East Midlands Gateway
Phase 2 (EMG2)

Design Team Response Document to Road Safety Audit 1

Response Report

Report Title:	EMG2 Highway Works, Stage 1 RSA Response Report
Document Number:	EMG2-BWB-GEN-XX-RP-CH-0020
Prepared By:	BWB Consulting Ltd
Overseeing Organisation:	National Highways and Leicestershire County Council
BWB Reference:	220500

Zone 1
 scale 1:1000@A1
 Proposed four-arm site access roundabout onto the realigned A453.

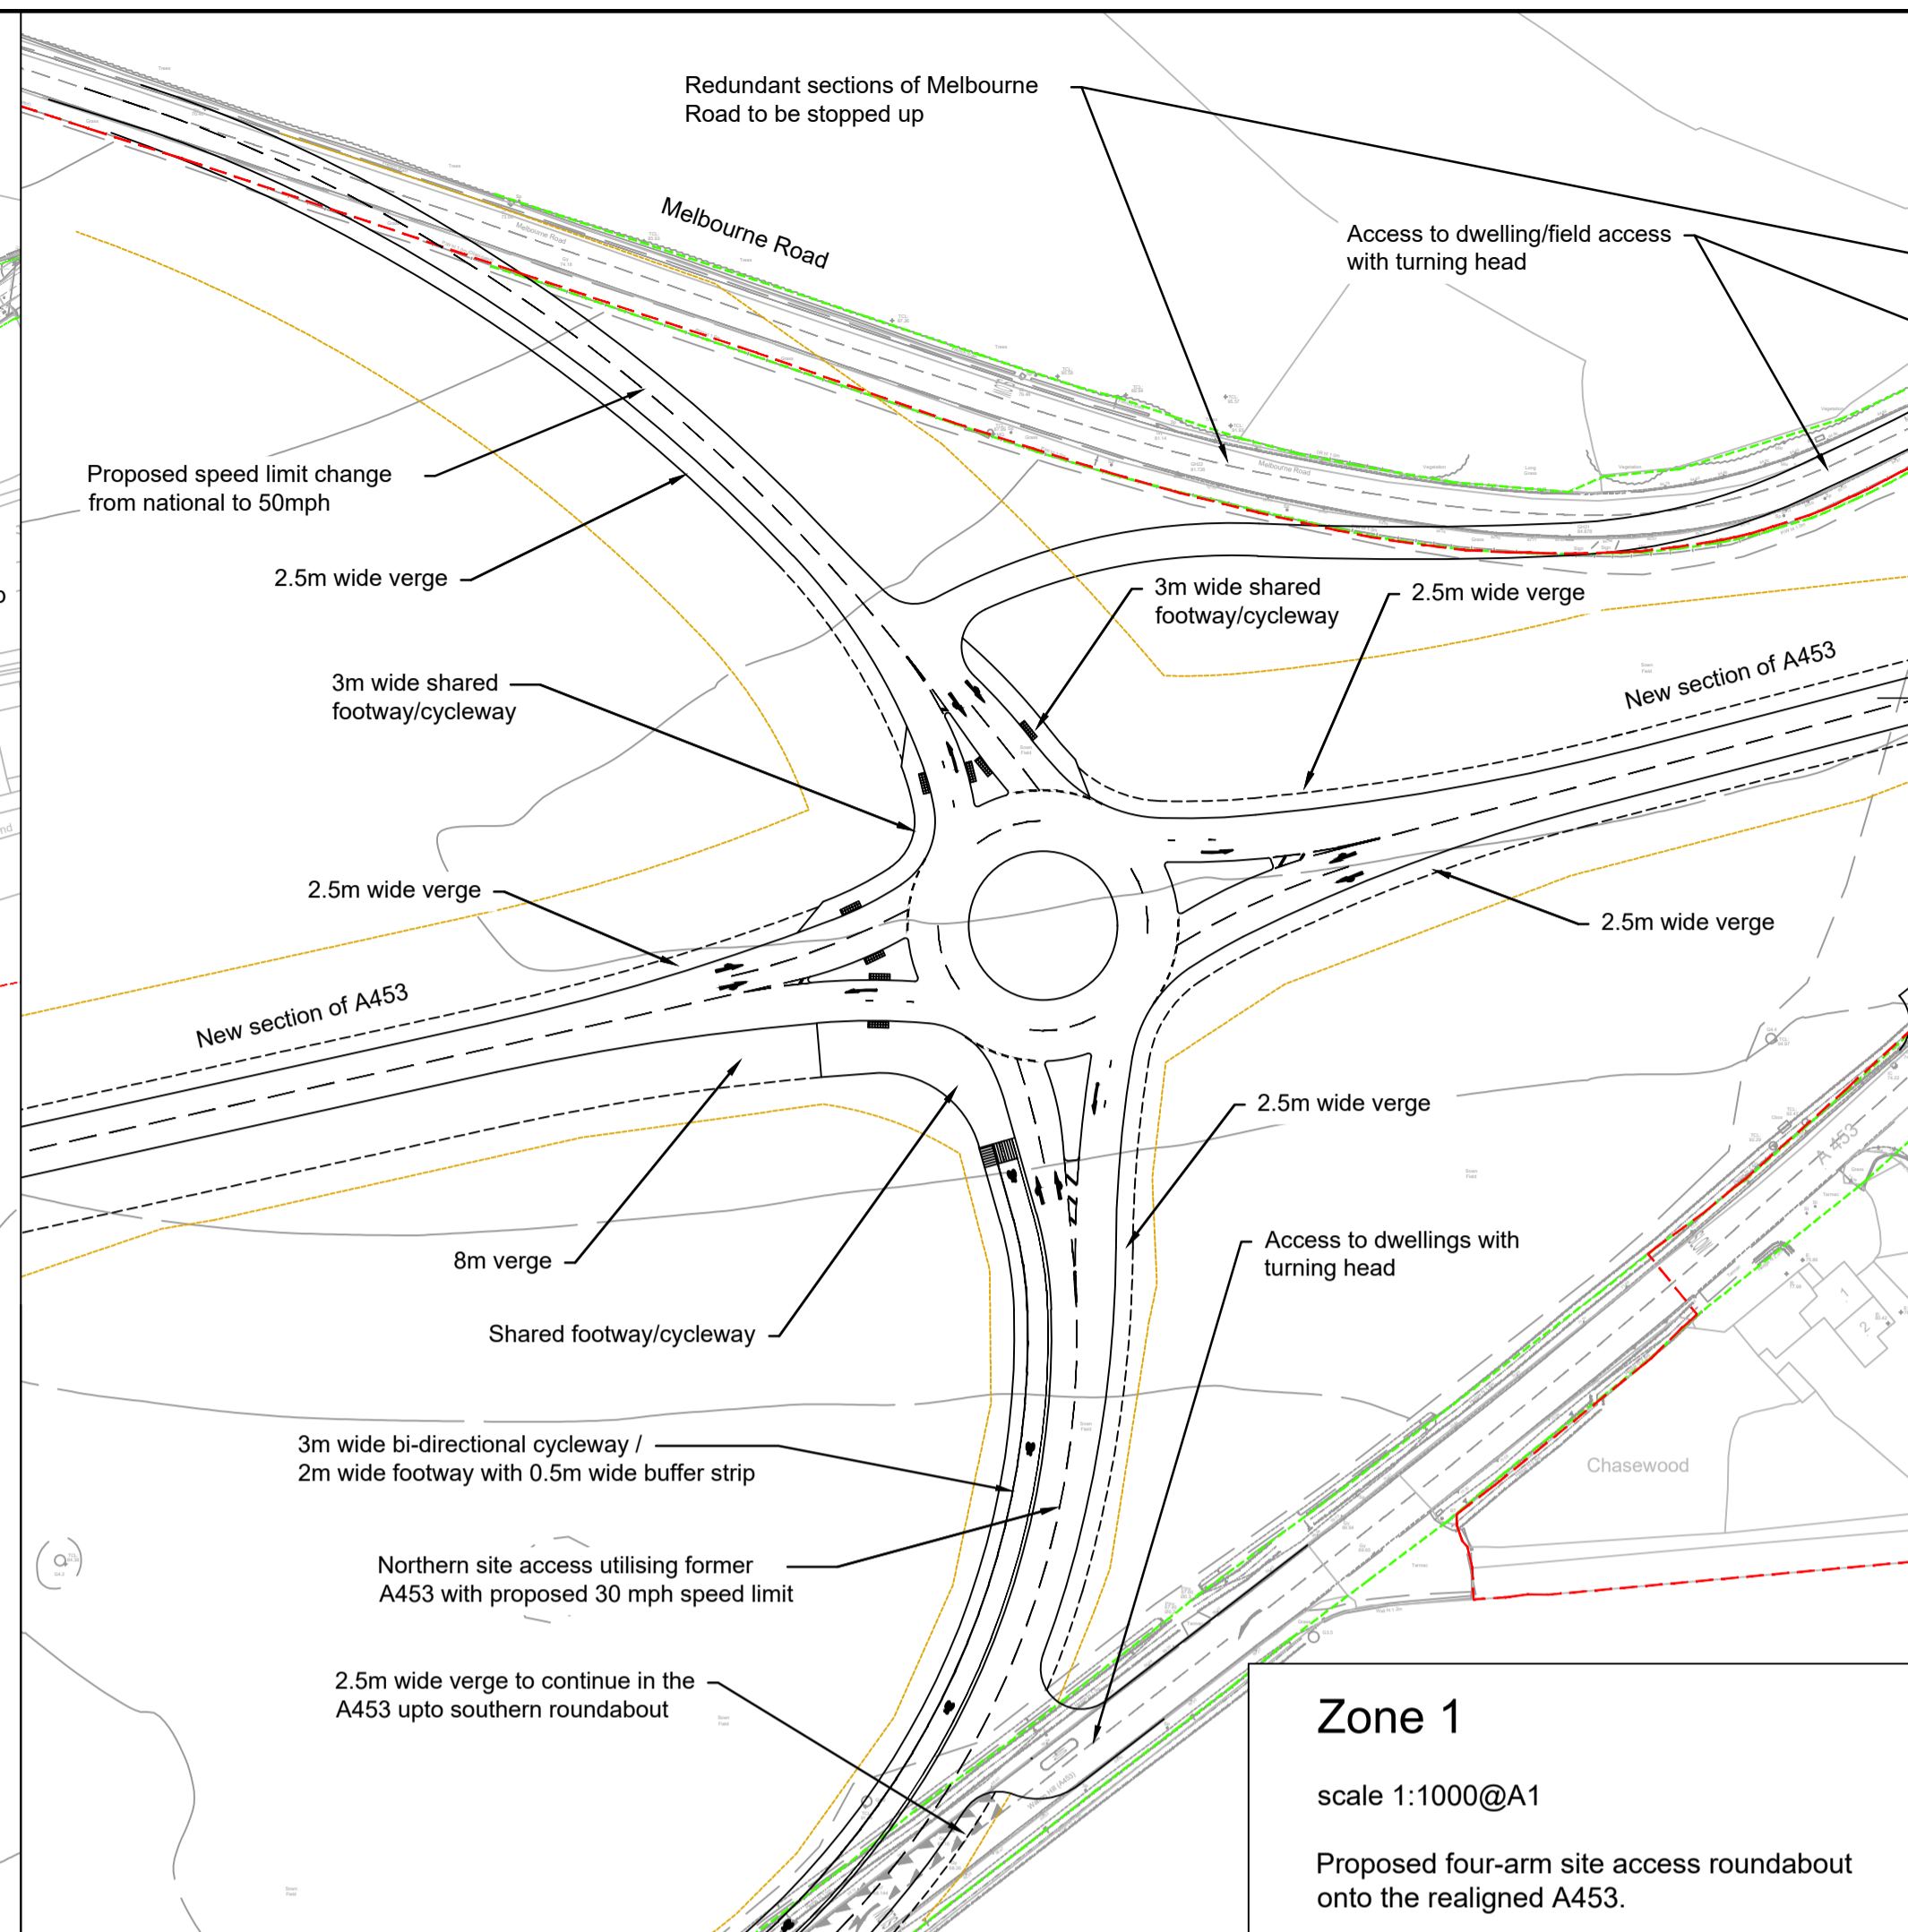
RSA Ref.	RSA Problem	RSA Recommendation	Design organisation response	Overseeing organisation response	Agreed RSA action
2.1	<p>Location: Works pack 6 – Site access junction</p> <p>Summary: Potential for side swipe collisions on the circulatory carriageway due to unclear lane destinations.</p> <p>The proposed site is accessed from the Hunters Roundabout and is provided with two lanes entering the site. However, it is not clear what movements can be undertaken from each of the approach lanes on the A453(E), into the site access. The swept path drawing presents a vehicle turning left into the site from Lane 2 of the flare on the A453(E), which could result in side swipe collisions if a vehicle was to continue straight ahead in Lane 1 on the same approach.</p>	<p>The lanes on the approaches to the junction should be marked clearly to ensure drivers are aware which lanes they can enter the site from. In addition, the provision of two lanes entering the access is questioned, if it is not possible to circulate the roundabout in two lanes to enter the site side by side. It is assumed this is for internal routing management and as a result, the lanes should be clearly marked as vehicles enter the site from the roundabout to ensure drivers are entering the site in the correct lane.</p>	<p>Lane arrows will be amended and lane direction sign will be added to ensure its clear what movements are permitted from each lane.</p>	<p>Agree with design organisation response</p>	<p>Amend lane direction arrows and provide lane direction sign.</p>

RSA Ref.	RSA Problem	RSA Recommendation	Design organisation response	Overseeing organisation response	Agreed RSA action
2.2	<p>Location: Works pack 6 – Site access junction</p> <p>Summary: Potential for side swipe collisions on the circulatory carriageway due to unclear lane destinations.</p> <p>The swept path drawings provided to the Audit Team present an HGV and a car circulating the roundabout side by side from the eastbound entry arm. It is unclear whether two HGVs would be able to circulate the roundabout side by side, but it is considered as a possible manoeuvre as HGVs could be turning right into the EMG2 site.</p> <p>This could result in side swipe collisions on the circulatory carriageway if two HGVs are unable to circulate side by side.</p>	<p>The swept path of two HGVs side by side circulating the roundabout should be reviewed.</p>	<p>It is not anticipated two HGVs would circulate the roundabout side by side when approaching from the west and this is not a requirement of CD 116. The tracking will however be reviewed to see the effect should two HGVs attempt this manoeuvre.</p> <p>In response to initial LCC response: The tracking drawings have been amended to show both 16.5m and 18.5m articulated vehicles can make all anticipated manoeuvres side by side</p>	<p>Side by side articulated vehicle swept paths are shown on the north side of the roundabout (dwg 0110 rev P04), but not for the south side.</p> <p>Drawing 0110 rev P04 shows that an 18.5m length articulated vehicle can generally perform the required manoeuvres without overrunning the kerblines. However, whilst it may just be the thickness of the lines, the swept paths are very close to or slightly overrunning the kerblines on the south side of the roundabout island for turning movements shown in the bottom right viewport. For the A453 straight ahead manoeuvres the swept paths show a slight amount of overrunning of the lane lines, but we consider this will be acceptable due to them be less prevalent than the standard 16.5m length vehicle</p>	<p>Vehicle tracking has been reviewed to confirm two HGVs (16.5 and 18.5m artics) can use the circulatory side by side</p>
